Response to Submissions Table

University of New South Wales – Biological Sciences Project

State Significant Development Application – 6674

Sheet Name
FLOOR PLAN - LOWER GROUND

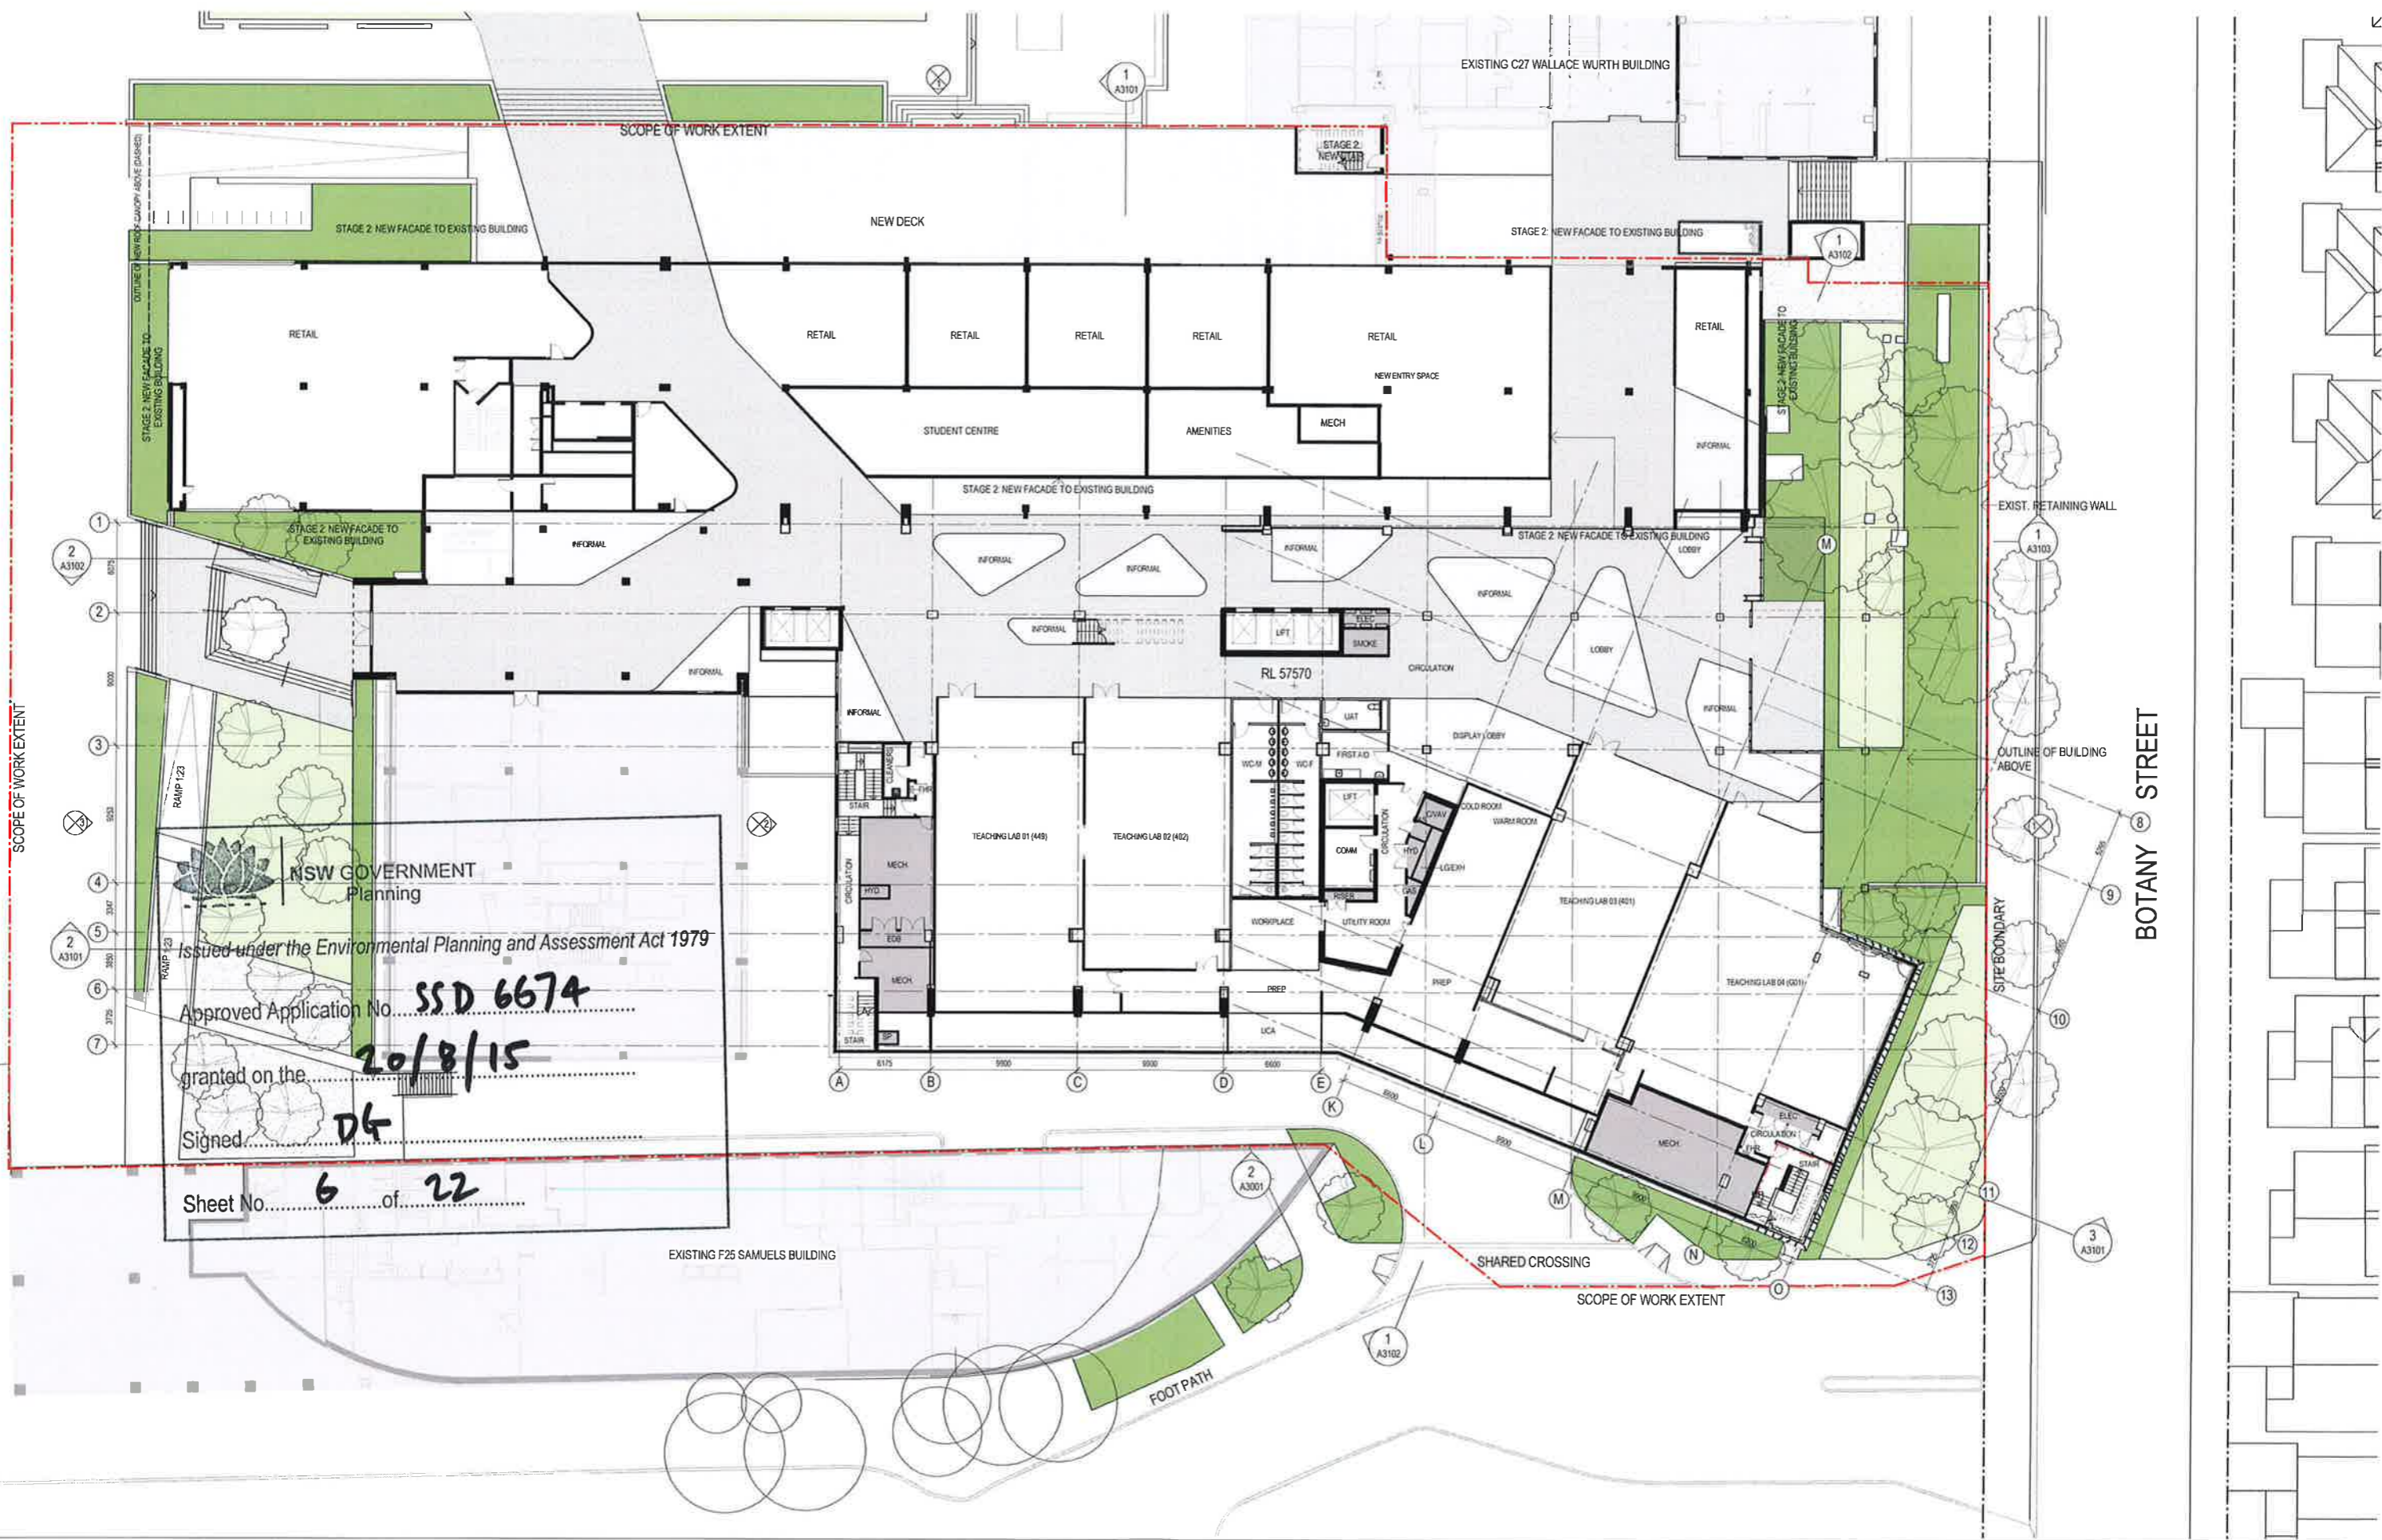
24. Finally, the proposed ground floor plans of the entrance stairs and retail premises on the eastern wing of the Biolink Building (D26) should illustrate the relationship with the wider context including the Chancellery Walk and adjoining campus buildings to the east.	▪ Refer to Section 2.2 of the RtS Report ▪ The retail units lead through to the proposed atrium between Building D26 and the proposed building (Building E26). This route will encourage engagement of the spaces both in the gardens and in the informal ground floor areas leading to the proposed teaching spaces.

1 EAST ELEVATION - FROM BOTANY STREET
SCALE 1 : 200

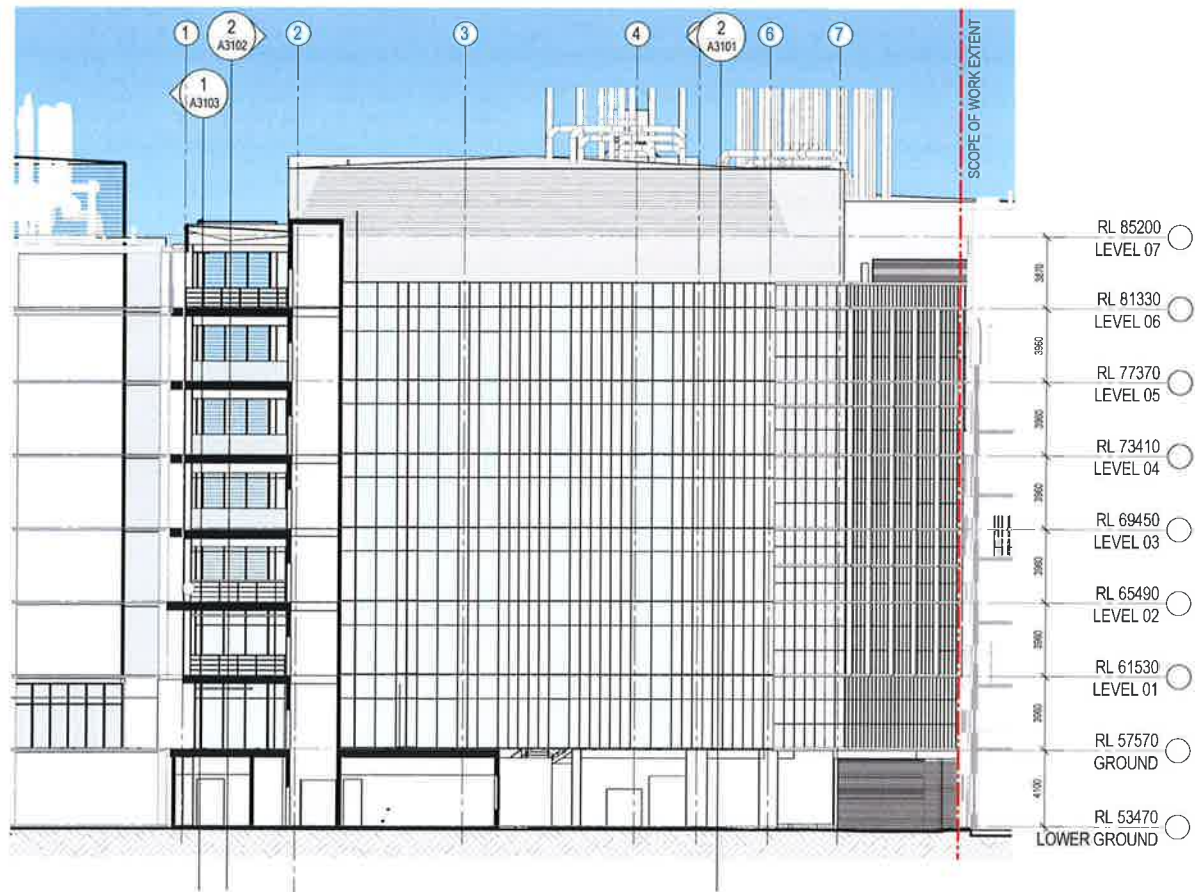
Submission Item	Response
6. Built form	
7. Further consideration should be given to the activation of the south eastern corner of the site or the treatment of this facade to provide an improved visual setting given Gate 11 is a designated entrance/exit to the campus and the eastern end of University Mall.	- East Mall via Gate 11 is currently a heavily trafficked route and the main service and vehicular access point for this part of the campus. As there are service access requirements for the proposed Biological Sciences building and access to the car parks it is essential to the functionality of this zone to retain this access. - With this premise the building has been designed to promote the car free areas along Chancellery Walk and around Michael Birt gardens. The main access for the building is via the gardens into the existing D26 building. Access from Botany Street has been encouraged to occur between the Wallace Wurth building and the existing D26 building in the recently constructed walkway adjoining with 'University Walk' (as an entry to the precinct not just the building). - All buildings on campus are entered from a precinct rather than a front door to the street. The south east corner of the building is purposely designed to discourage activity around the heavily trafficked area.

20. A re-design of the frontage of the south-eastern wing should be considered in order to promote a more transparent and active frontage that relates to the public domain at pedestrian level and reduces the stagnant appearance of the buildings frontage. This will also require a reconfiguration of the internal floor plan at the ground floor level in providing more active uses other than the proposed plant and stair access to the upper floor levels.

Original Noise Logging Data (November 2014)

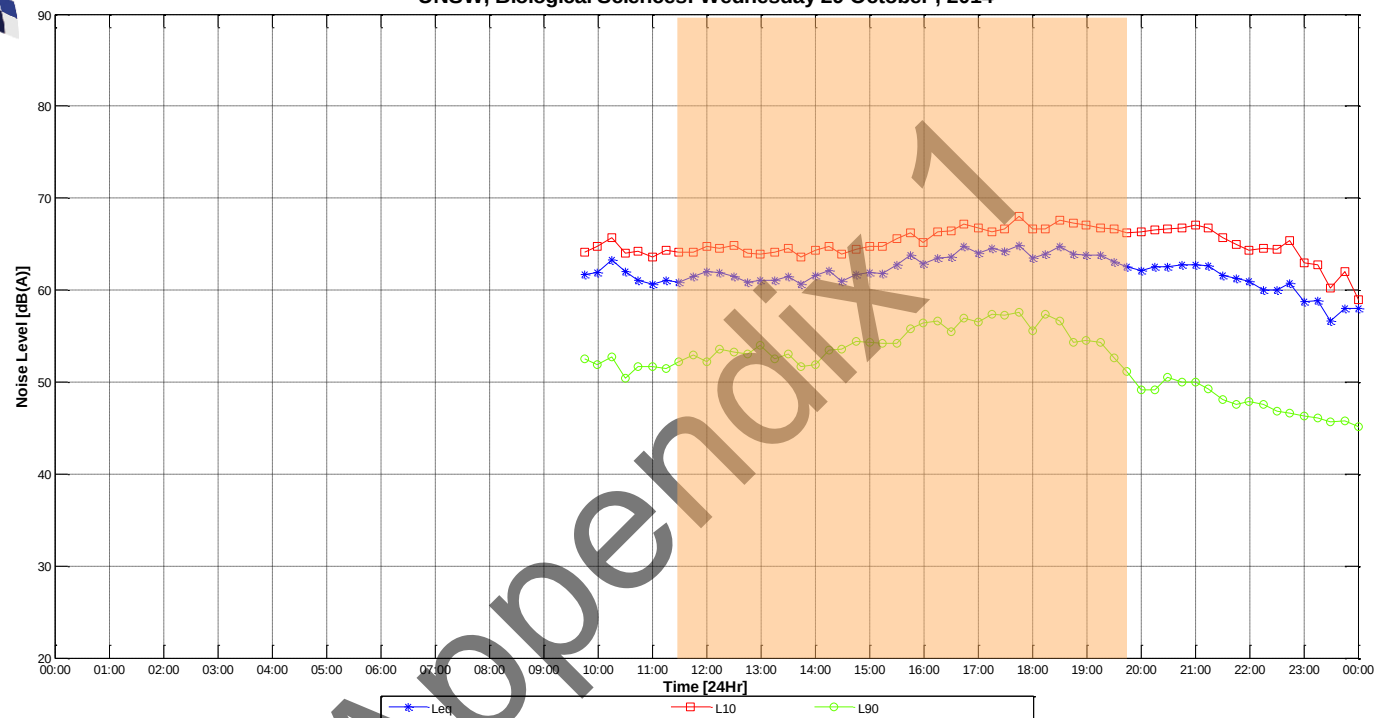
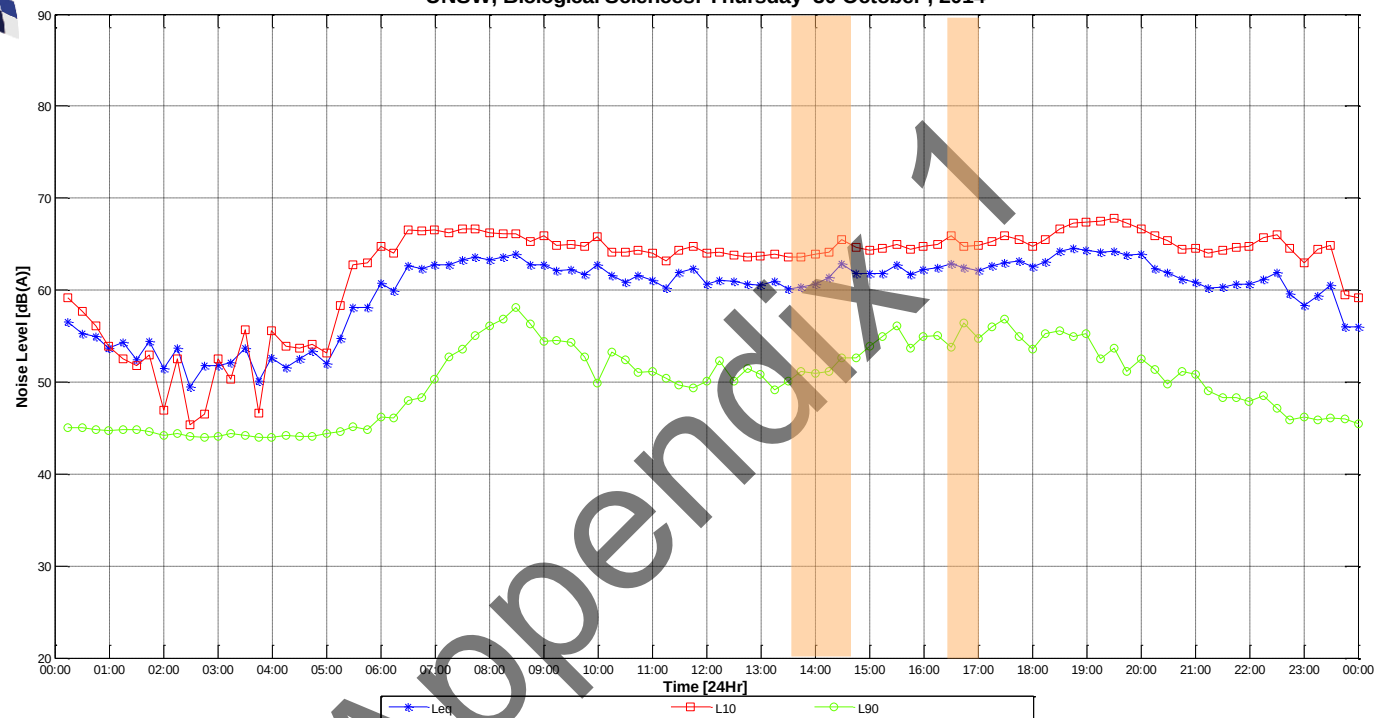
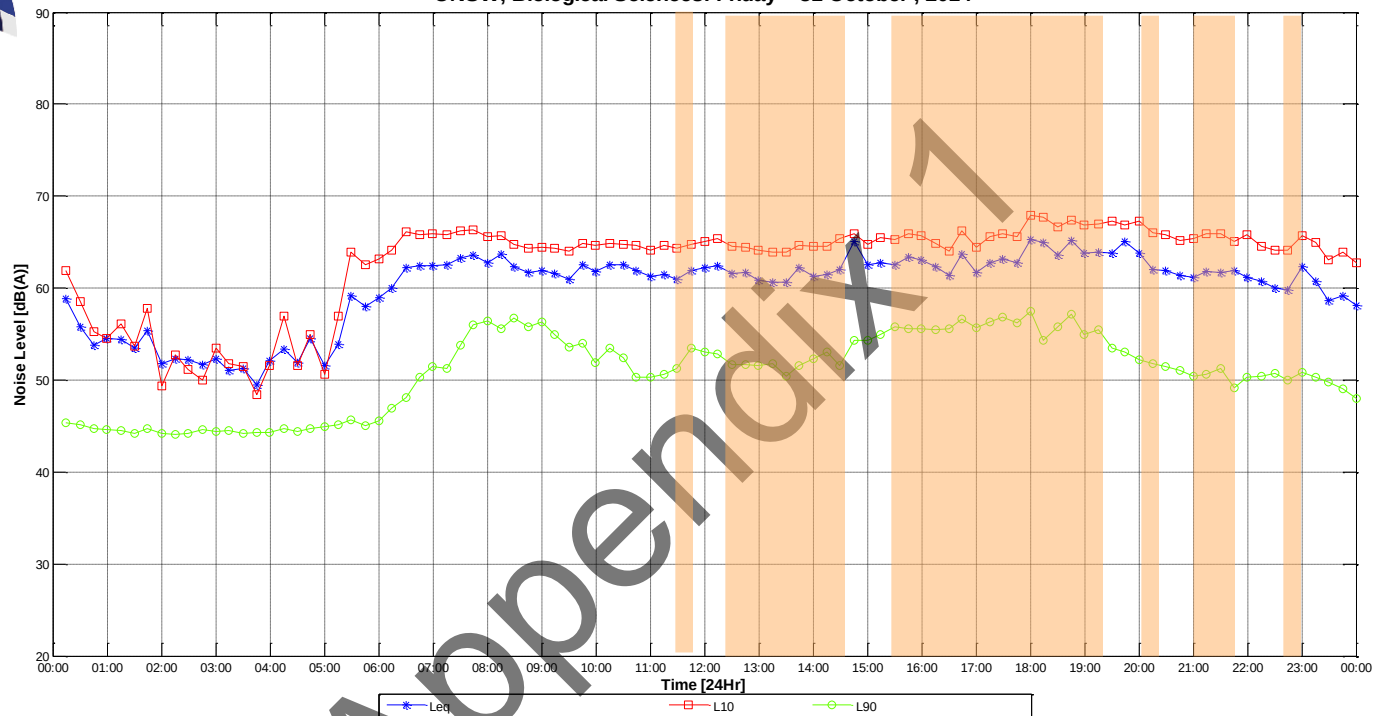
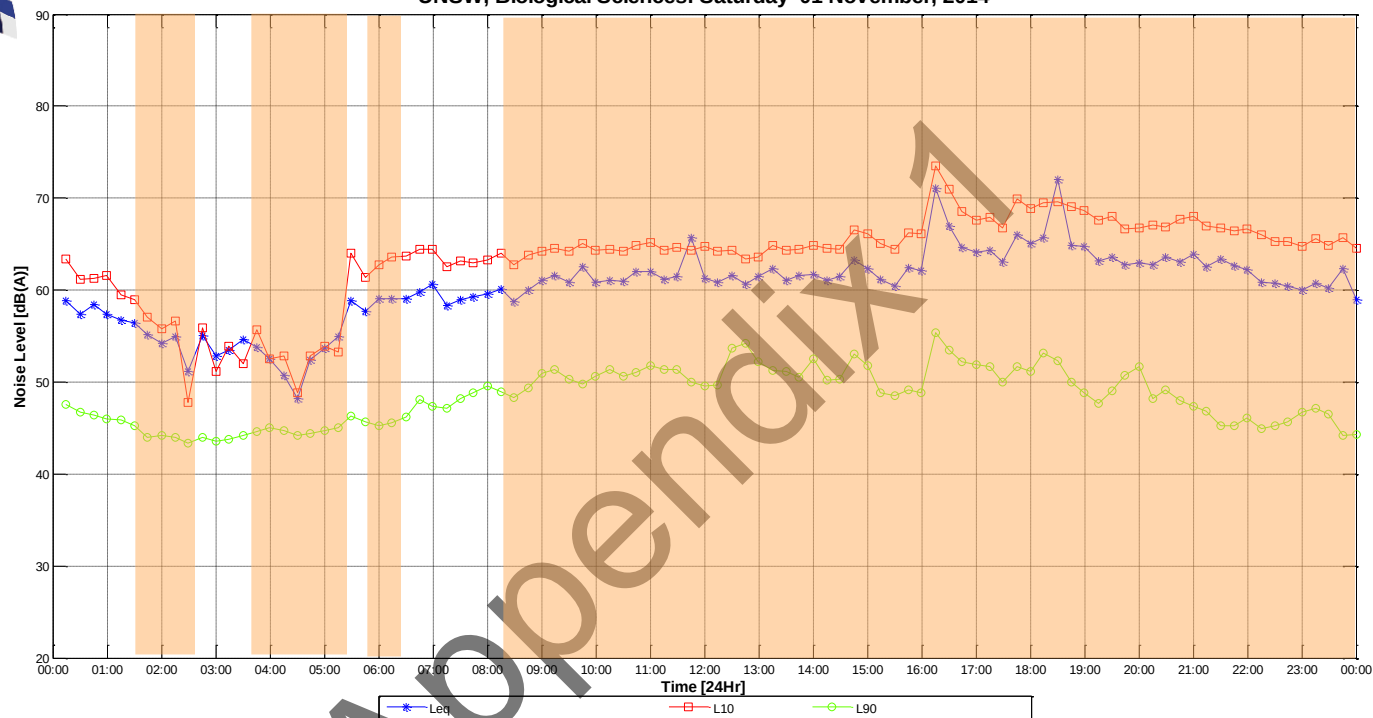
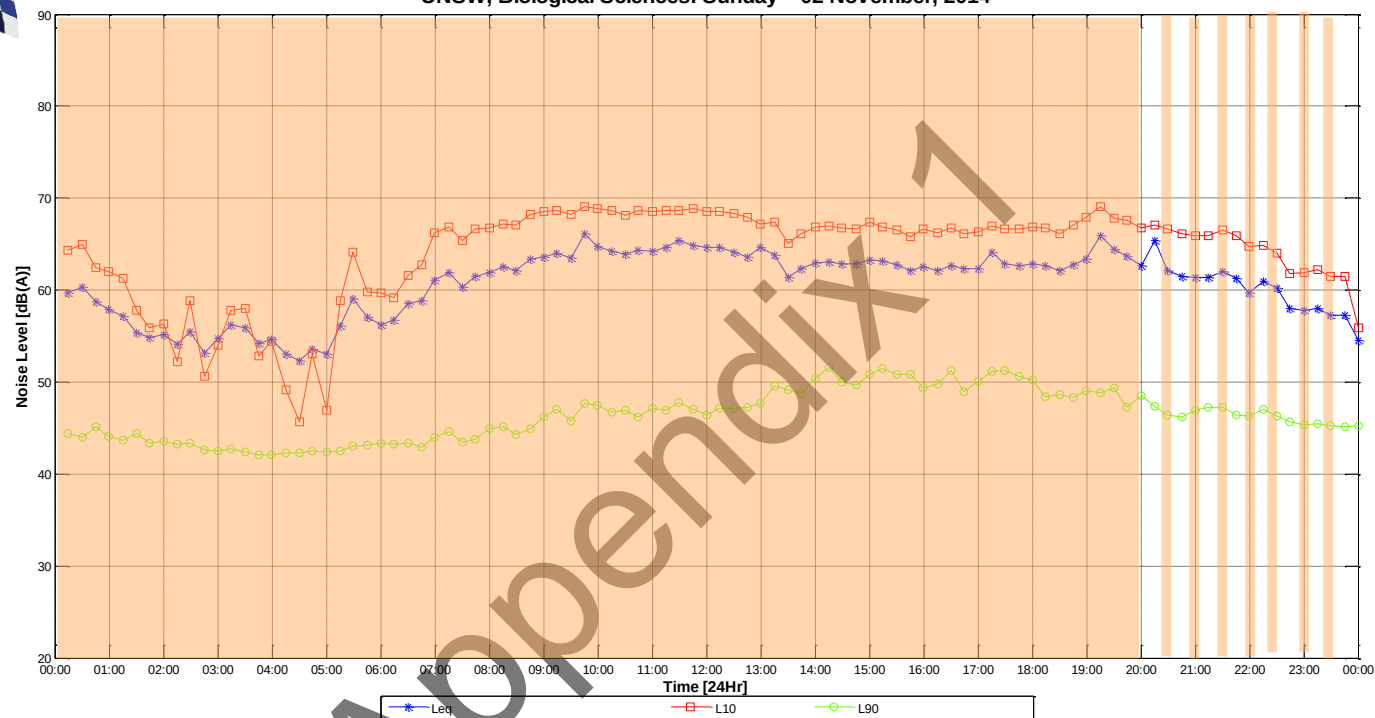
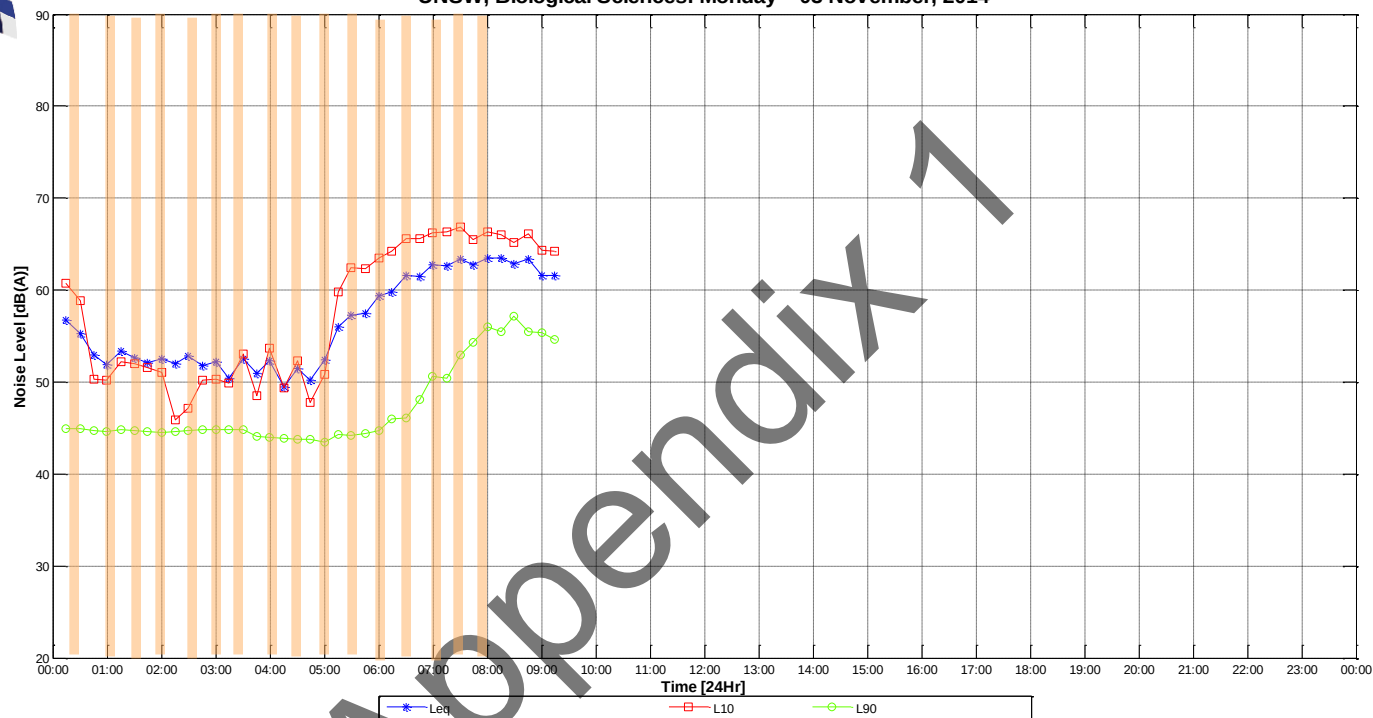
10. Further background noise monitoring should be undertaken to ensure the project specific noise levels have been established in accordance with the requirements of the Industrial Noise Policy.	- Acoustic Logic have prepared a response report, addressing the relevant submissions raised above (see Appendix D), and in support of the original acoustic report submitted with the SSD. - This response include further background noise level monitoring as requested by Council. - Refer to Section 2.5 of the RtS for detailed response
